**Ref: PAX91.323780 – 10 year planning permission for Ballinlee Wind Farm consisting of 17 no. wind turbines, a permanent 110kV substation and ancillary development located in Ballincurra, Ballingayroure, Ballinlee North & South, Ballinrea, Ballyreesode, Camas North & South, Carrigeen, Knockuregare, Ballybane and other townlands in County Limerick.**

My name is Michael Ryan, I am a Chartered Surveyor with over 23 years' experience. Over 10 years of which is in the high voltage industry, including wind farms, solar farms, battery energy storage systems and substations. I wish to object to planning application for Ballinlee Wind Farm PAX91.323780. This planning application **does not** comply with either "Draft Revised Wind Energy Development Guidelines December 2019" or "Wind Energy Development Guidelines (2006)".

Figure 2-6: Wind Energy Zoning

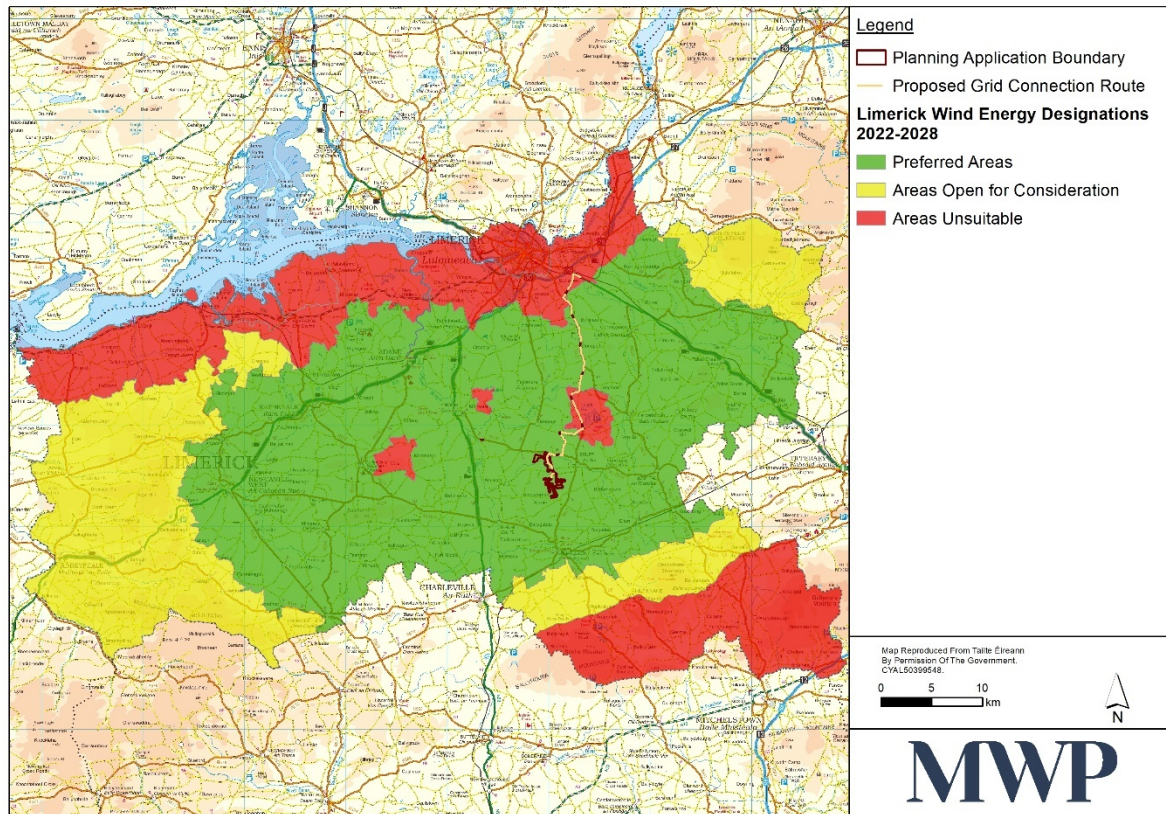
On page 2-10 of document “Chapter 02 Description of the Proposed Development” of the Main EIAR submitted by Ballinee Green Energy Ltd, two significant sections of this development is within “**Tier 3 - Unsuitable, Exclusion Zone, Not Normally Permissible Area.**” under the National Territory Mapping for Renewable Electricity Renewable Energy Directive III Article 15B - National Territory Mapping for Grid-Scale Onshore Wind in Ireland.

Therefore, this project is within an area exclusion zone and planning permission must be refused.

Figure 2-8: Wind Farm Site Layout

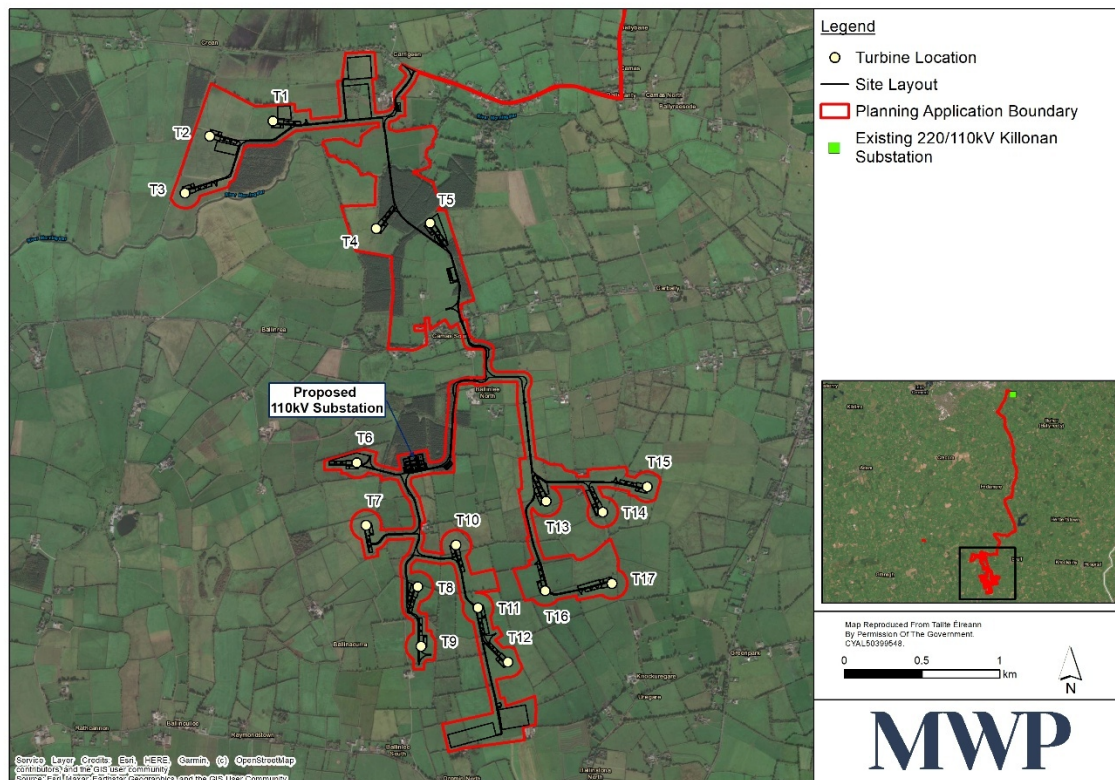
Two rotor blades is 136m long. The below 7 wind turbines, T1, T2, T3, T5, T6, T9 and T15 are all too close to adjoining boundaries.

The below 3 wind turbine distances are too close together in crosswind direction.

Seven times the rotor diameter is  $136\text{m} \times 7 = 952\text{m}$ . The below 22 distances between wind turbines are less than seven times the rotor diameter ( $=7d$ ) in the prevailing downwind direction.

Wind Turbine 1 is less than 3.5 times (only 456m) the wind turbine's rotor diameter from a 110kV Overhead Line.

Wind Turbine 2 is less than 3.5 times (427m) the wind turbine's rotor diameter from a 110kV Overhead Line.

House at ITM grid Coordinates X 559480 Y 633385 is only 531m from Wind Turbine 9. All homes must be a minimum of 4 times the tip height from a wind turbine, irrespective of who owns the home. The curtilage of house at ITM grid Coordinated X 560627 Y 632880 is less than a minimum of 4 times the tip height from a wind turbine.

Wind Turbine 1 is, firstly, too close to an adjoining boundary. Wind Turbine 1 is only 110m from an adjoining boundary, this must be at least 136m.

Wind Turbine 1 is, secondly, only 417m in the prevailing downwind direction of Wind Turbine 2. This must be at least 952m.

Thirdly, Wind Turbine 1 is only 730m in the prevailing downwind direction of Wind Turbine 3. This must be at least 952m.

Wind Turbine 2 is firstly, too close to two adjoining boundaries.

Secondly, too close to an 110kV Overhead line.

And thirdly, it is only 399m in the prevailing downwind direction of Wind Turbine 3.

Wind Turbine 3 is too close to two adjoining boundaries, and secondly, too close to an 110kV Overhead line.

Wind Turbine 5 is only 350m in the prevailing downwind direction of Wind Turbine 4. This must be at least 952m.

Wind Turbine 5 is too close to an adjoining boundary.

Wind Turbine 6 is too close to an adjoining boundary.

Wind Turbine 7 is within 3 rotor diameters of Turbine 6 in a cross-wind direction.

Wind Turbine 8 is within 3 rotor diameters of Turbine 9 in a cross-wind direction.

Wind Turbine 9 is too close to an adjoining boundary.

Wind Turbine 9 is within 4 times the Tip Height of a house.

Wind Turbine 10 is only 364m in the prevailing downwind direction of Wind Turbine 8. This must be at least 952m.

Wind Turbine 11 is only 442m in the prevailing downwind direction of Wind Turbine 9. This must be at least 952m.

Wind Turbine 11 is within 3 rotor diameters of Turbine 12 in a cross-wind direction.

Wind Turbine 12 is only 559m in the prevailing downwind direction of Wind Turbine 9. This must be at least 952m.

Wind Turbine 12 is too close to an adjoining boundary.

Wind Turbine 13 is only 644m in the prevailing downwind direction of Wind Turbine 10. This must be at least 952m.

Wind Turbine 13 is only 813m in the prevailing downwind direction of Wind Turbine 11. This must be at least 952m.

Wind Turbine 14 is only 370m in the prevailing downwind direction of Wind Turbine 13. This must be at least 952m.

Wind Turbine 14 is only 625m in the prevailing downwind direction of Wind Turbine 16. This must be at least 952m.

Wind Turbine 15 is too close to an adjoining boundary.

Wind Turbine 15 is only 329m in the prevailing downwind direction of Wind Turbine 14. This must be at least 952m.

Wind Turbine 15 is only 657m in the prevailing downwind direction of Wind Turbine 13. This must be at least 952m.

Wind Turbine 15 is only 936m in the prevailing downwind direction of Wind Turbine 16. This must be at least 952m.

Wind Turbine 15 is only 657m in the prevailing downwind direction of Wind Turbine 17. This must be at least 952m.

Wind Turbine 16 is too close to an adjoining boundary.

Wind Turbine 16 is only 446m in the prevailing downwind direction of Wind Turbine 11. This must be at least 952m.

Wind Turbine 16 is only 508m in the prevailing downwind direction of Wind Turbine 12. This must be at least 952m.

Wind Turbine 16 is only 820m in the prevailing downwind direction of Wind Turbine 8. This must be at least 952m.

Wind Turbine 16 is only 876m in the prevailing downwind direction of Wind Turbine 9. This must be at least 952m.

Wind Turbine 17 is only 430m in the prevailing downwind direction of Wind Turbine 16. This must be at least 952m.

Wind Turbine 17 is only 875m in the prevailing downwind direction of Wind Turbine 11. This must be at least 952m.

Wind Turbine 17 is only 837m in the prevailing downwind direction of Wind Turbine 12. This must be at least 952m.

Drawing Nr 7 highlights that the actual usable area on the site where wind turbines can be placed is very small, when the setback distances from homes and the distance from adjoining property boundaries is taken into consideration.

The attached drawing Nr. 7 shows the area in pink, which is too close to homes, the area in green which is too close to adjoining properties and the very small area where wind turbines are actually possible in blue.

When taking the above 5 facts into consideration, ***It impossible to fit 17 wind turbines on this site. The absolute maximum is 6 wind turbines.***

One Turbine 200m east of T2's current location.

One Turbine between T4 & T5's current location.

One Turbine at between T6 & T7's current location.

One Turbine between T8, T10 & T11's current locations.

One Turbine at T13 & T14's current location.

One Turbine between T16 & T17's current location.
